From: Simon Davis
Sent: 10 December 2021 14:20
To: Grace Palmer [REDACTED]
Subject: RE: Planning Consultation on: BN/134/21/DOC

Thank you for consulting us on this discharge of conditions application. We have the following comments regarding conditions 10 and 11.

Condition 10

Checked By RW	Checked Date 21.04.21	Drawn By RD	Drawn Date 20.04.21
Client Drawing No.		Scale 1:20	(AT A1 SIZE)
PBA Drawing No. 108.5009.551			Revision F

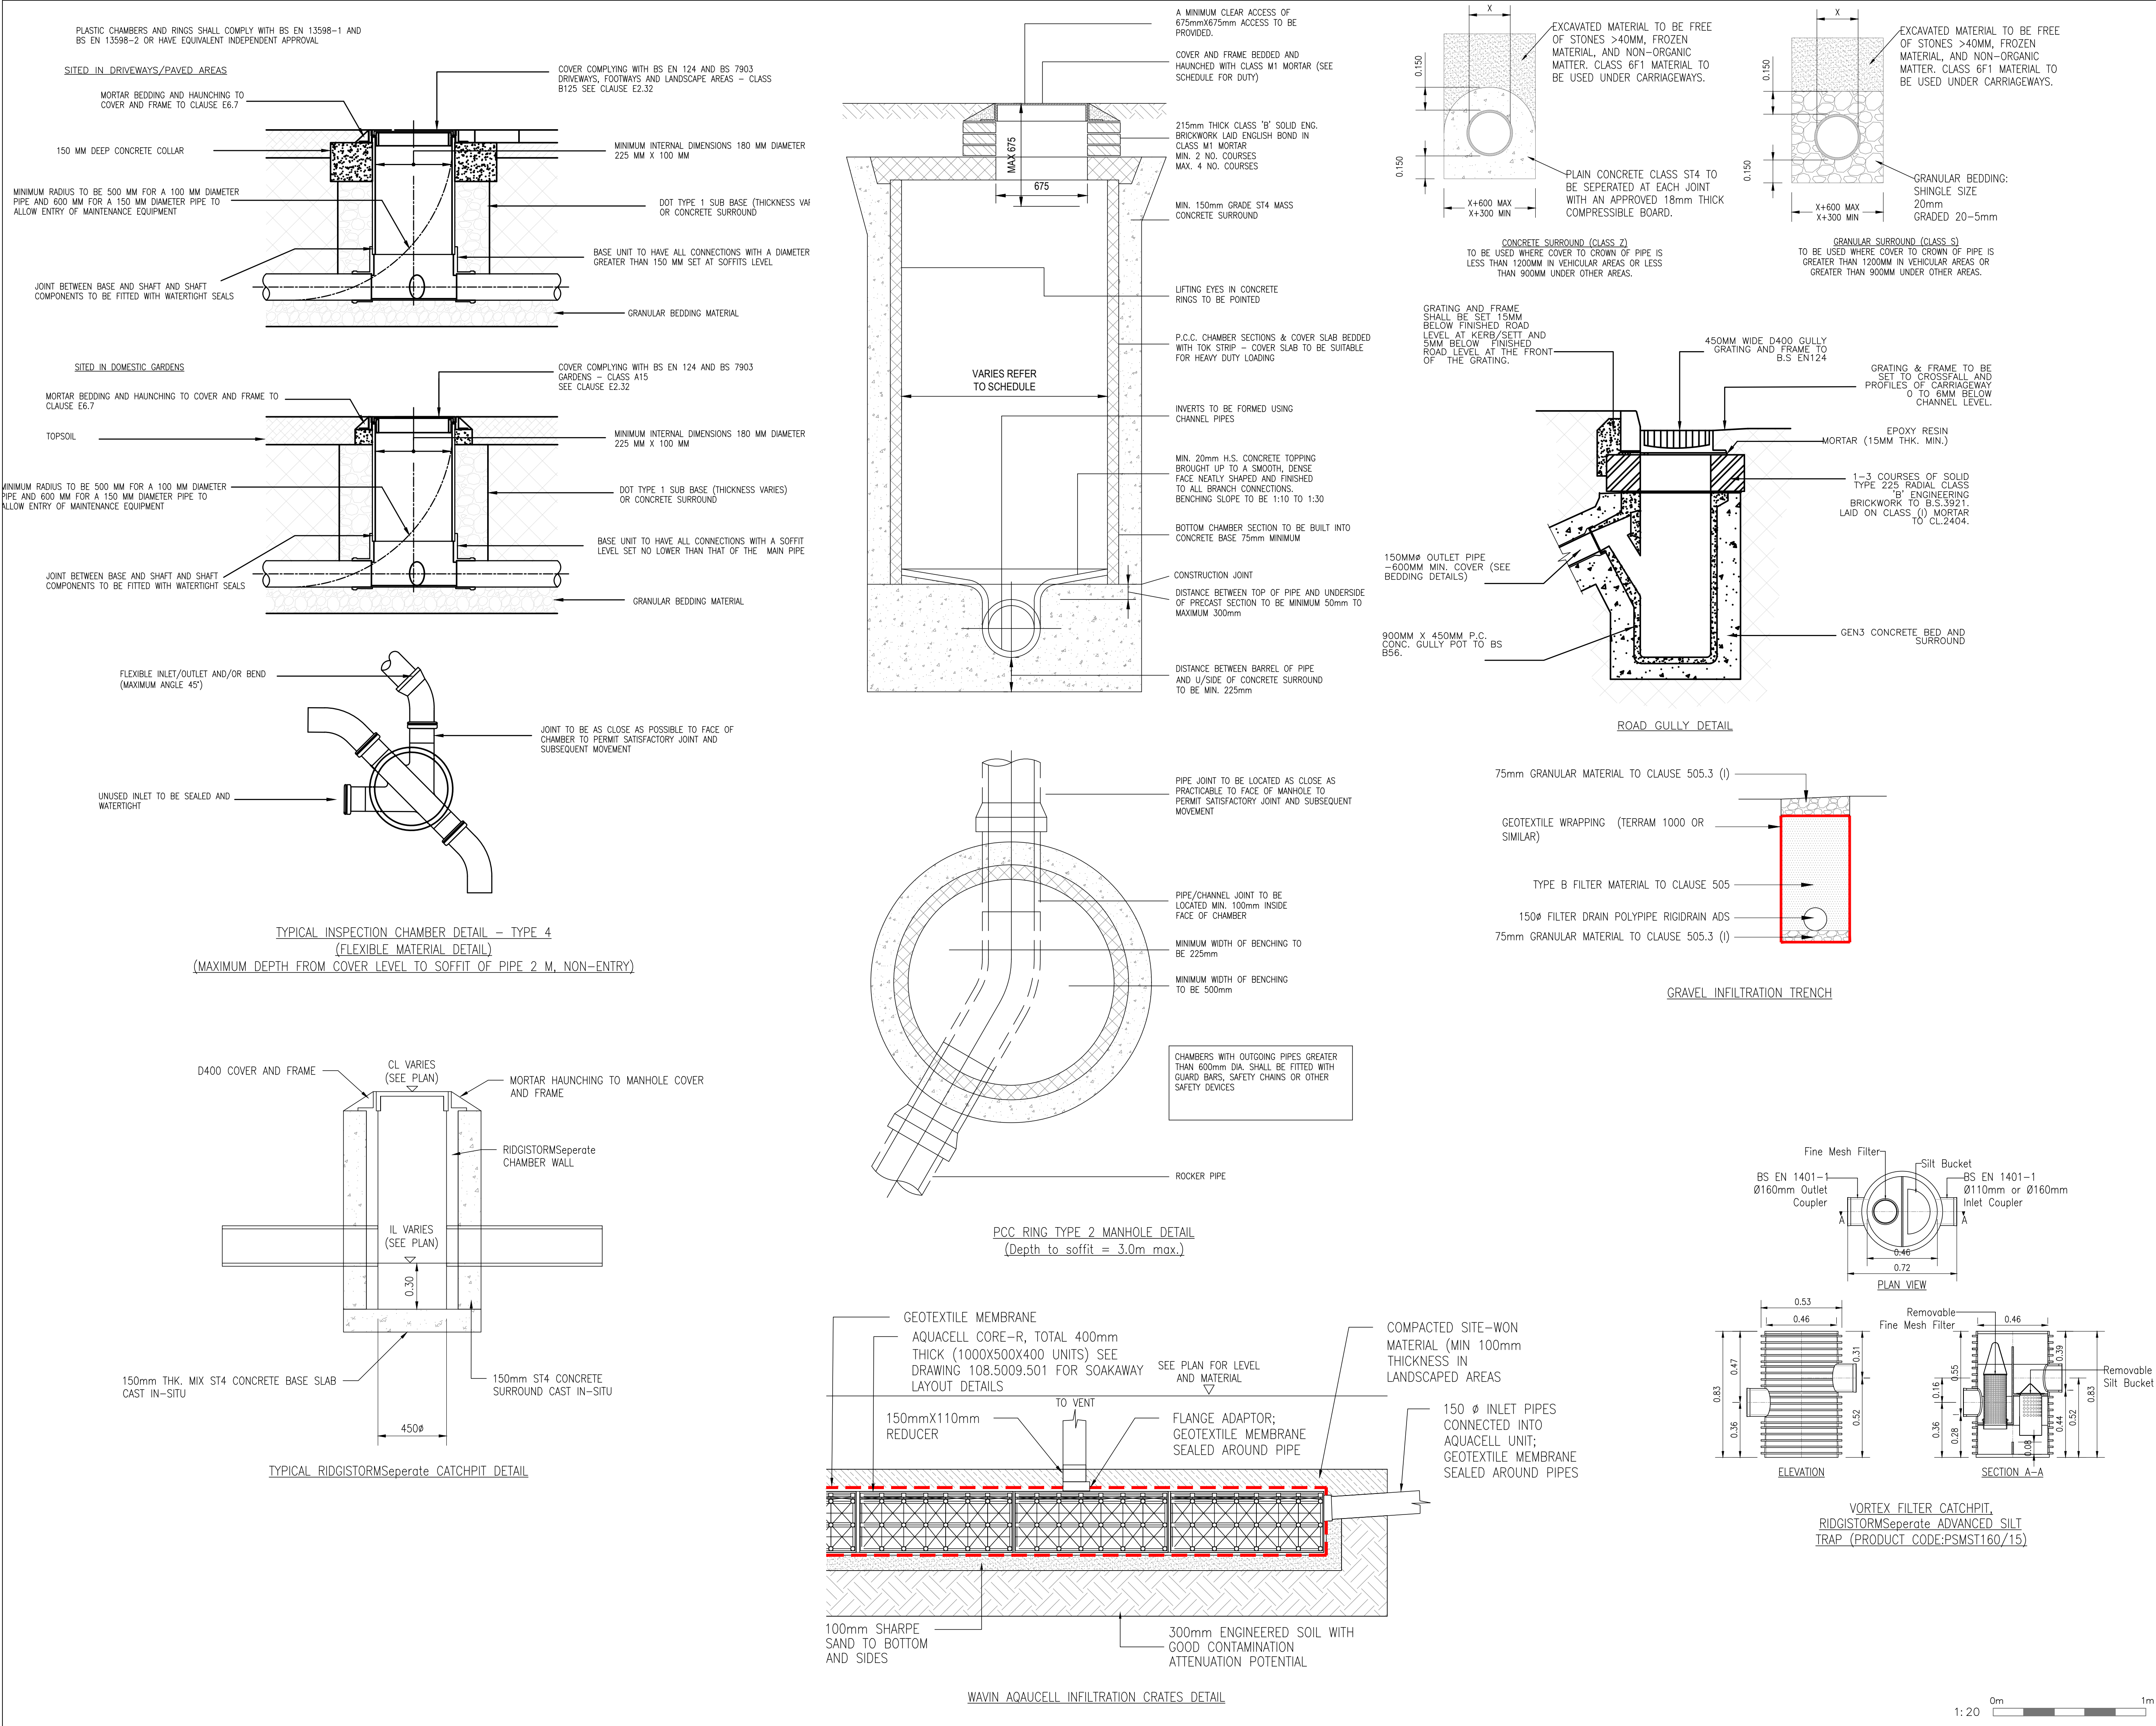
8. The soakaway construction detail needs to be improved. As crate depth varies, the detail should not state total 400mm thick, and should instead state that the depth varies and reference the plans that depth is detailed on. Minimum cover depth should be stated.

9. Please provide a construction detail drawing of granular soakaways.

Note on soakaway construction detail amended to state: *AQUACELL CORE-R 1000X500X400 UNITS, EXACT DEPTH AND AREA OF SOAKAWAYS VARY, SEE DRAWING 108.5009.501 FOR SOAKAWAY LAYOUT DETAILS.*
Drawing 551 updated accordingly

A granular soakaway detail is shown on drawing 551.F

Checked By RW	Checked Date 19.04.2021	Drawn By CLP	Drawn Date 19.04.2021
Client Drawing No. -	Scale 1:200	(AT A1 SIZE)	
PBA Drawing No. 108.5009.705	Revision G

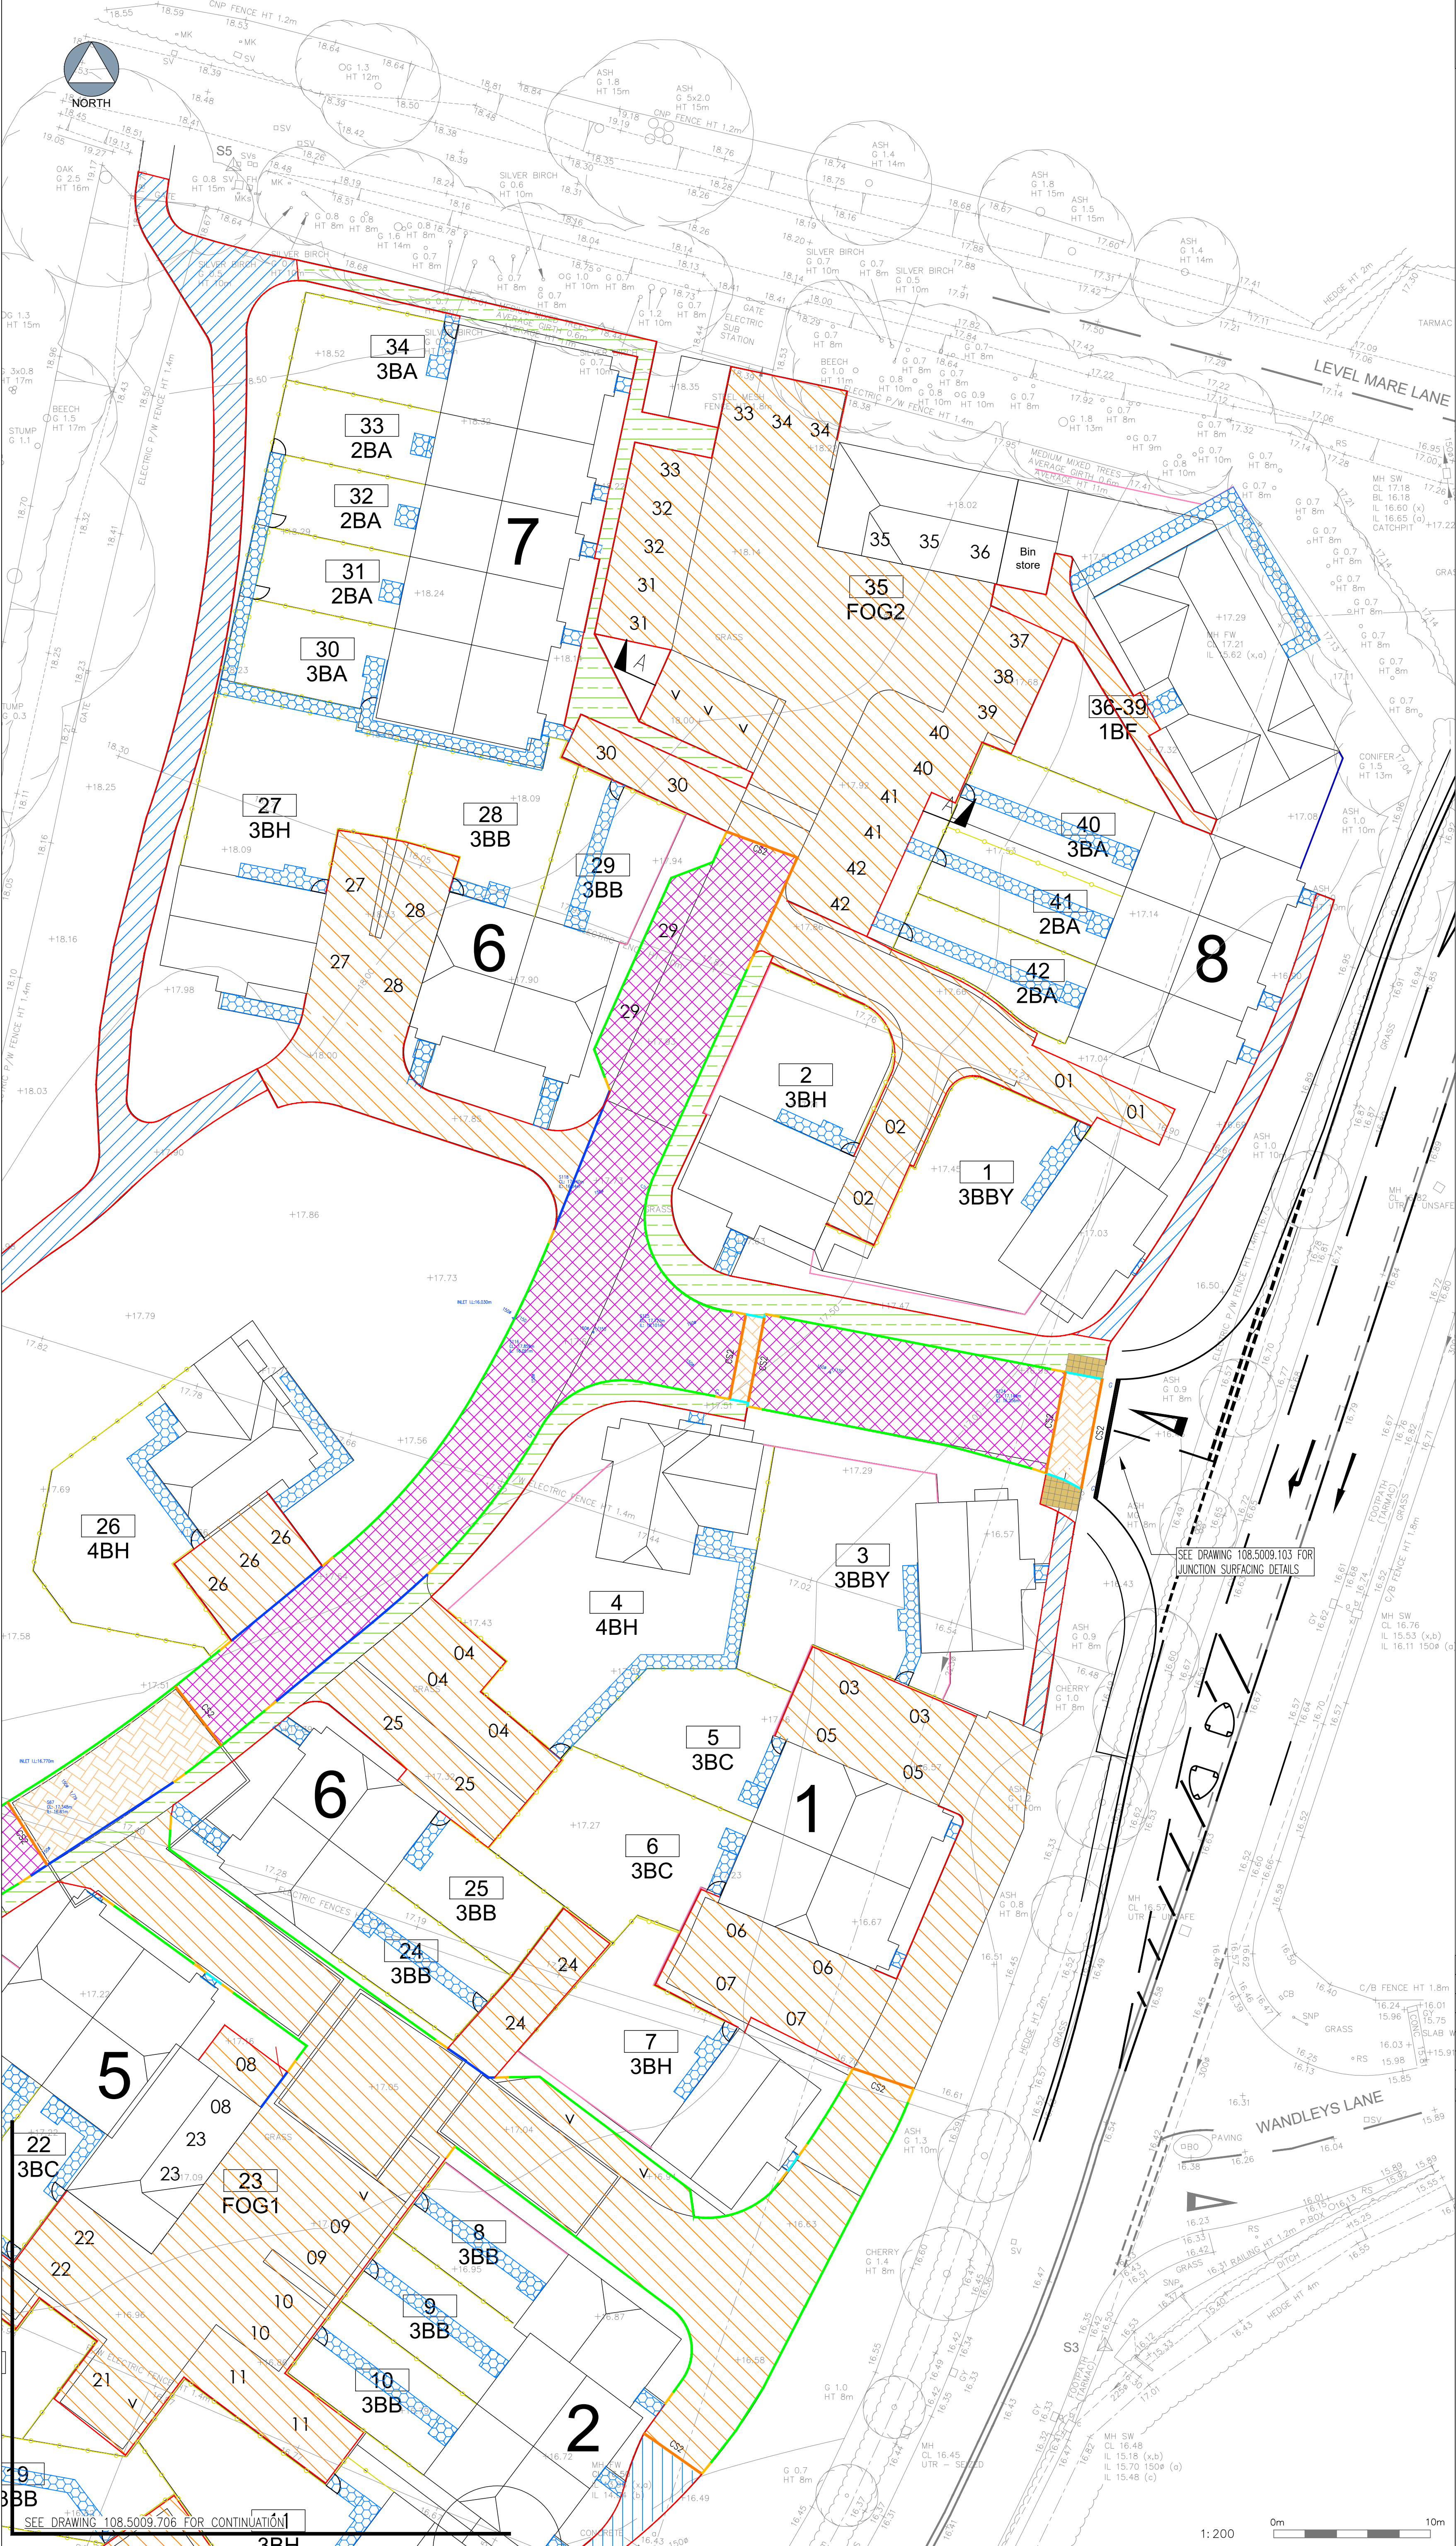
7. Capping layer below type 3 on the permeable paving must state “no fines”. Please also clearly label the base geotextile.

Permeable paving specification updated to state ‘no fines’ on capping layer – drawings 703, 704, 705, 706, 751, 552 and drawings 501-506 updated accordingly
